KIRKLEES METROPOLITAN COUNCIL INVESTMENT & REGENERATION SERVICE

DELEGATED DECISION TO DETERMINE PLANNING APPLICATIONS

Reference No:	2026/62/90144/E
Site Address:	Land off, Leak Hall Road, Denby Dale, Huddersfield, HD8 8NJ
Description:	Erection of detached dwelling with associated access and car parking
Recommending Officer:	Elenya Jackson

Officer Report

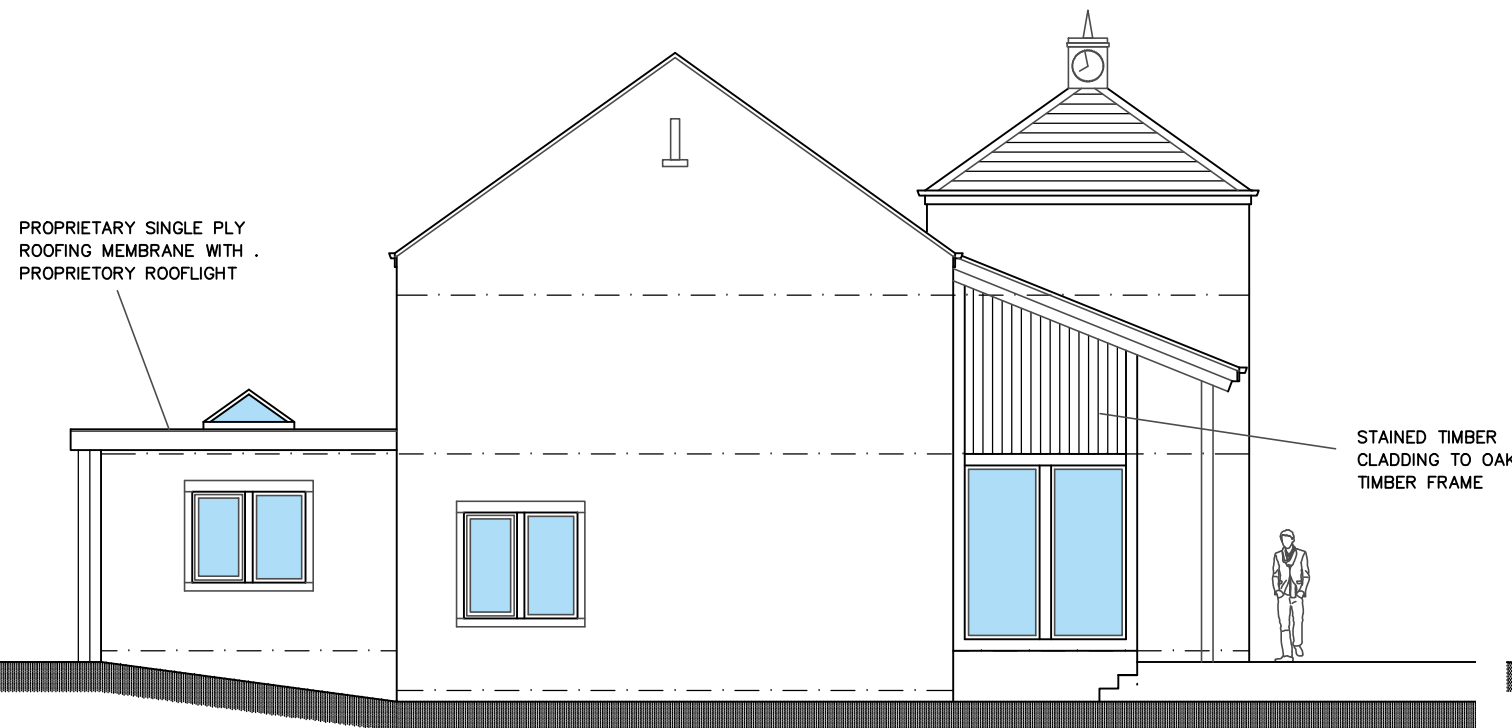
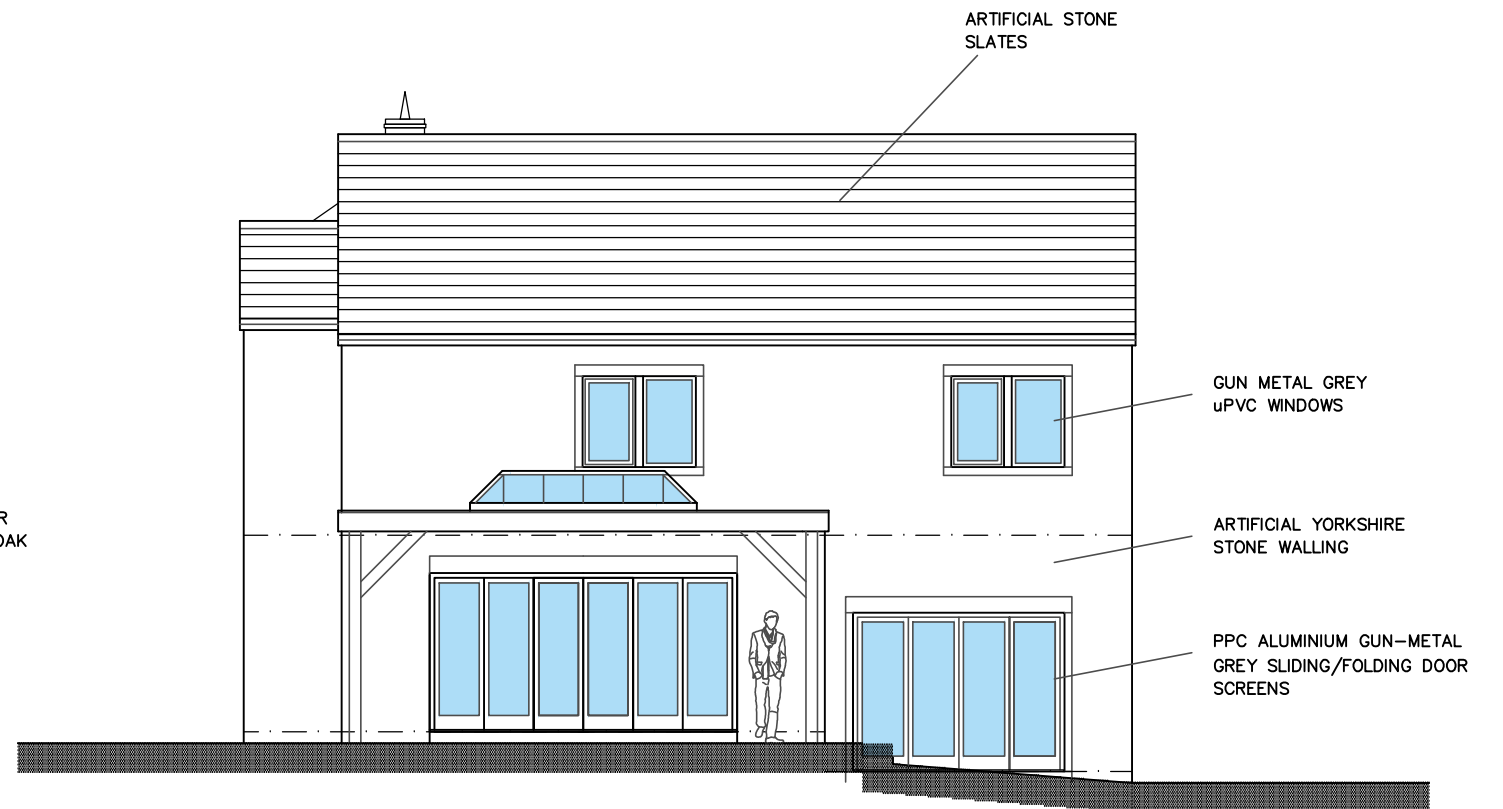
Overlooking: The proposal would be set on a lower level than the rear of no.6; however, it would feature several side facing windows. From reviewing the plans, officers consider that these would all be for non habitable rooms and could therefore be conditioned to be obscured.

Overlooking: The proposal would have side facing windows at ground floor level which would be adjacent to the side facing windows at no.5 which officers understand to be habitable rooms. It is considered that all the side facing windows on the proposal are secondary and it would not be unreasonable to condition them to be obscured.

Officers consider it necessary to add a condition preventing the addition of further side facing windows to ensure no overlooking relationships are created on site.

SITE PLAN
AS EXISTING

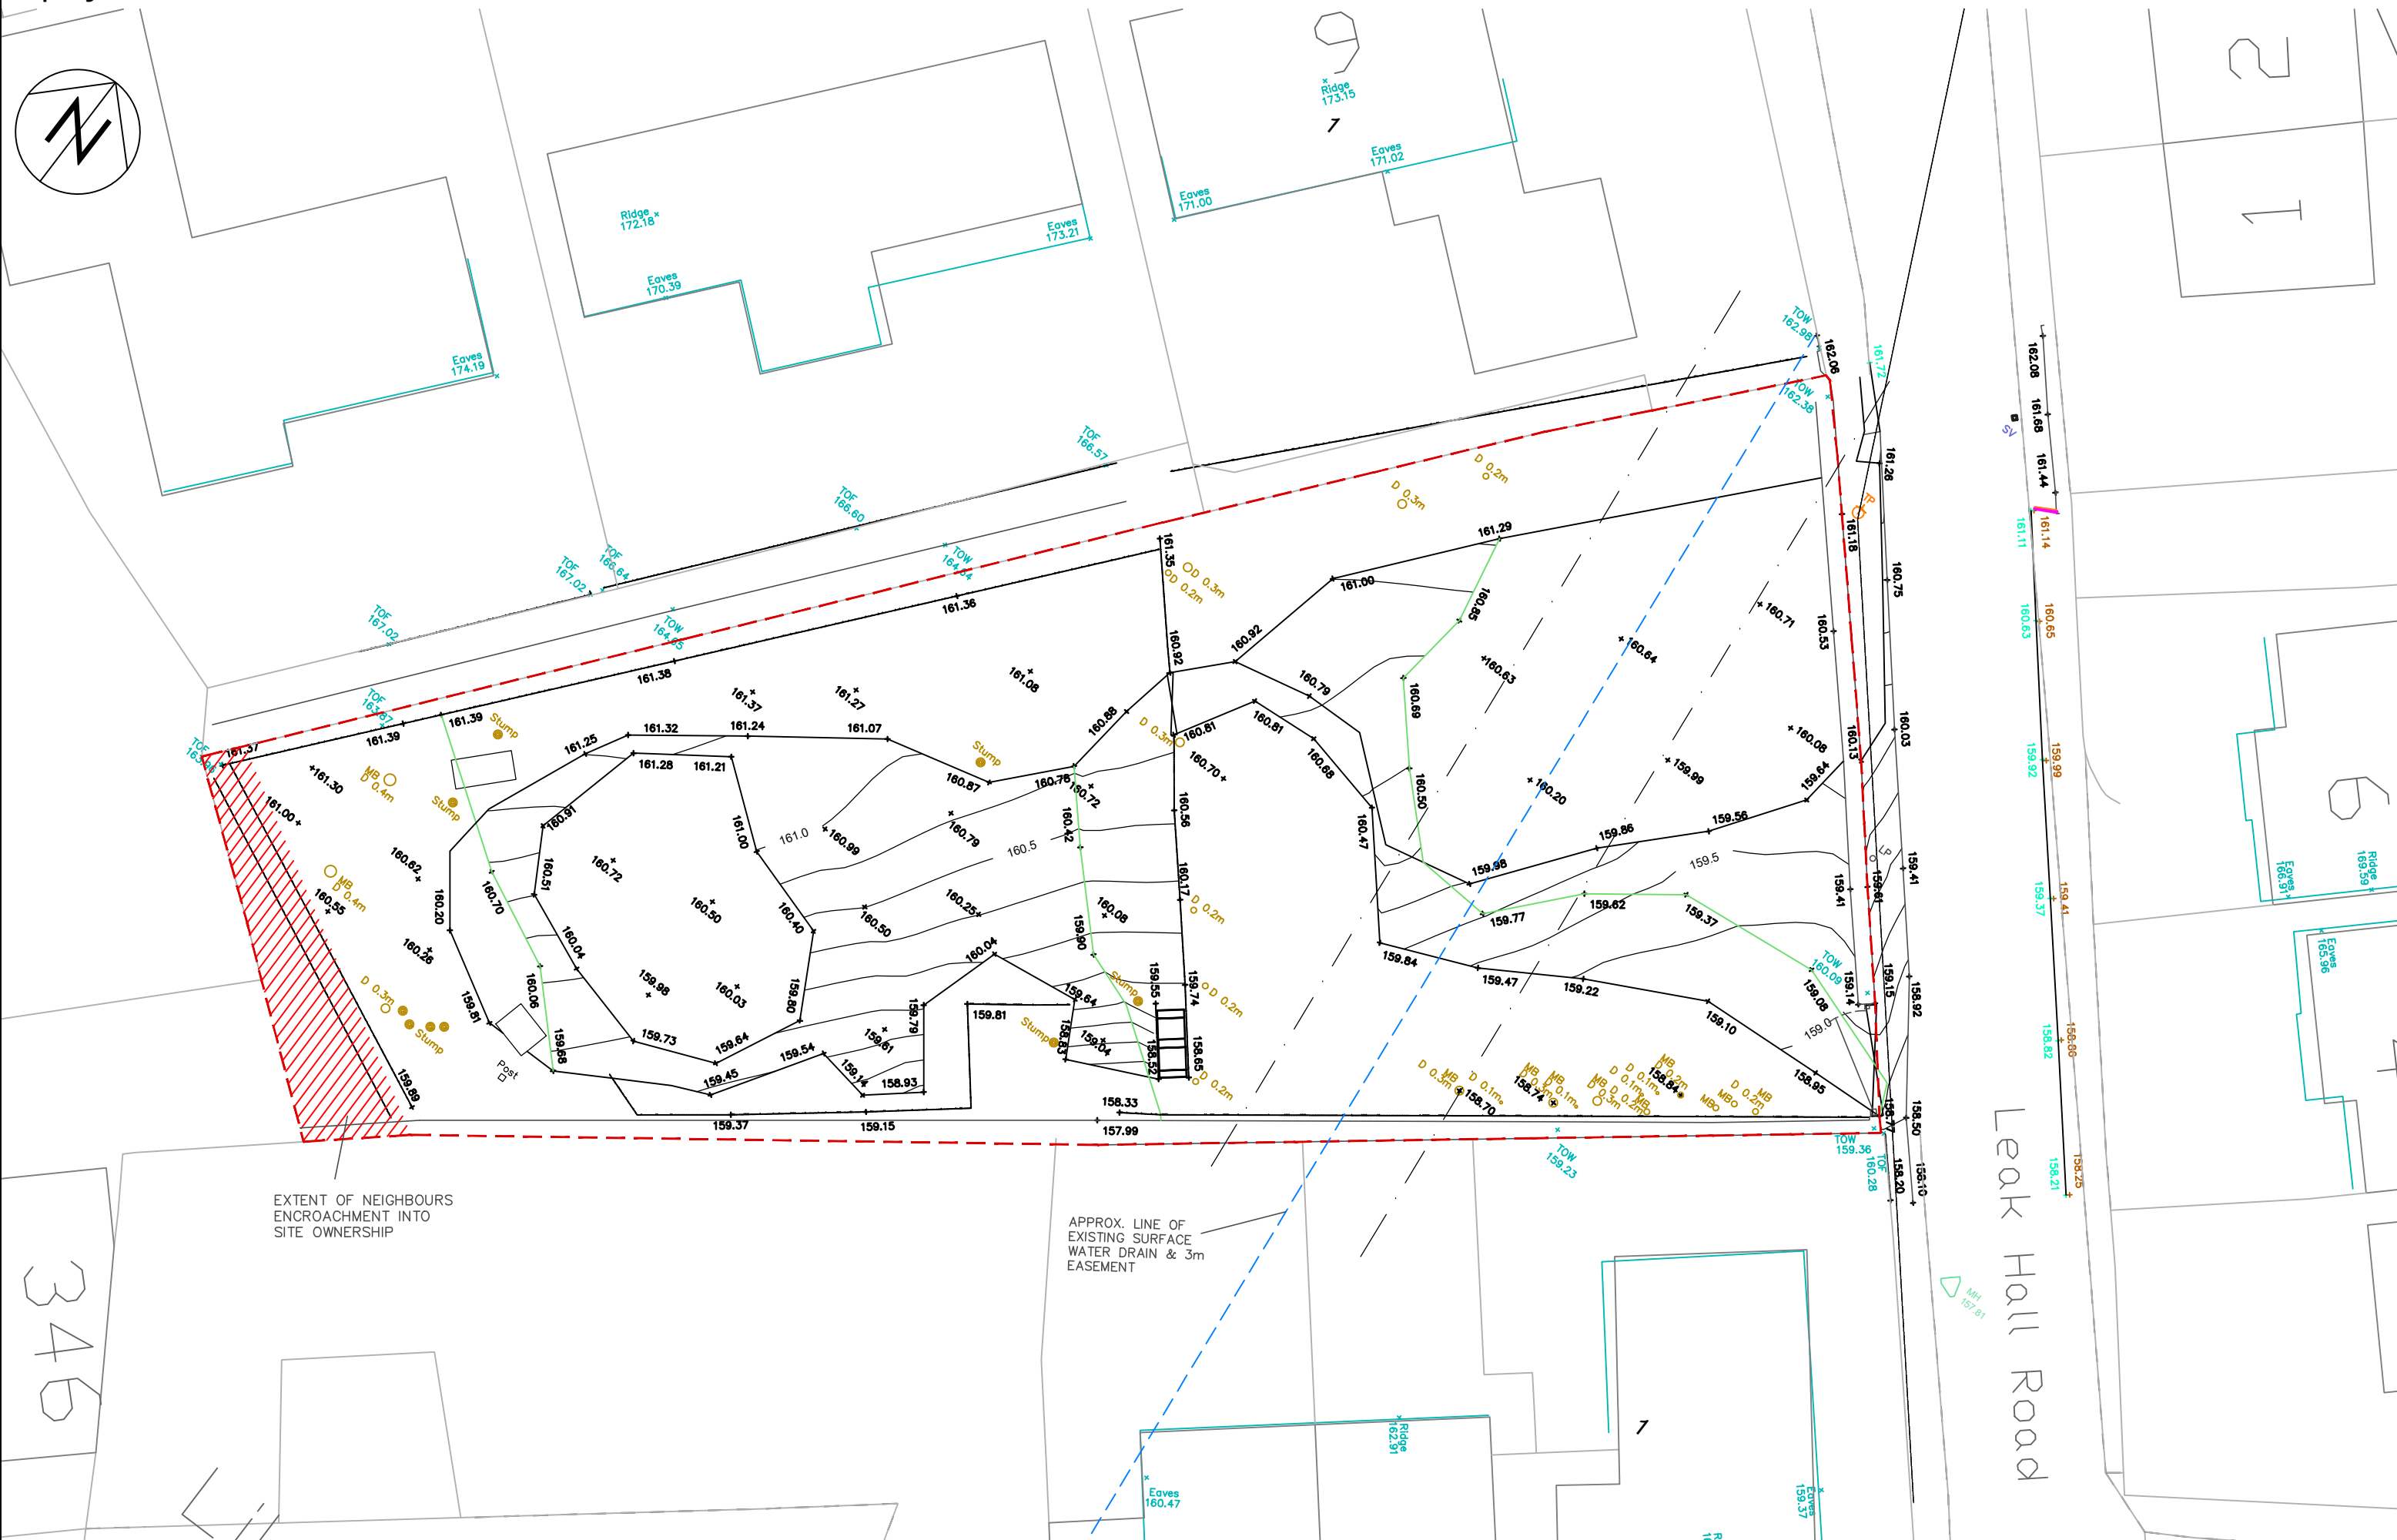
KC Highways Development Management have been informally consulted as part of the application. Initially it was requested that visibility splays were provided; however, as the plans have been updated to show the wall to the

front of the site would be reduced to allow for better visibility, this is considered acceptable.

Officers note that bin presentation points have not been provided on the plan and this shall therefore be conditioned to ensure this does not result in bin blight or obstruction of the highway.

13. Before the development commences, any retaining walls adjacent to the existing highway including any modification to the existing retaining wall adjacent to Leak Hall Road shall be submitted and approved by the Highway Authority in writing. The approved scheme shall be implemented prior to the commencement of the proposed development and thereafter retained during the life of the development.
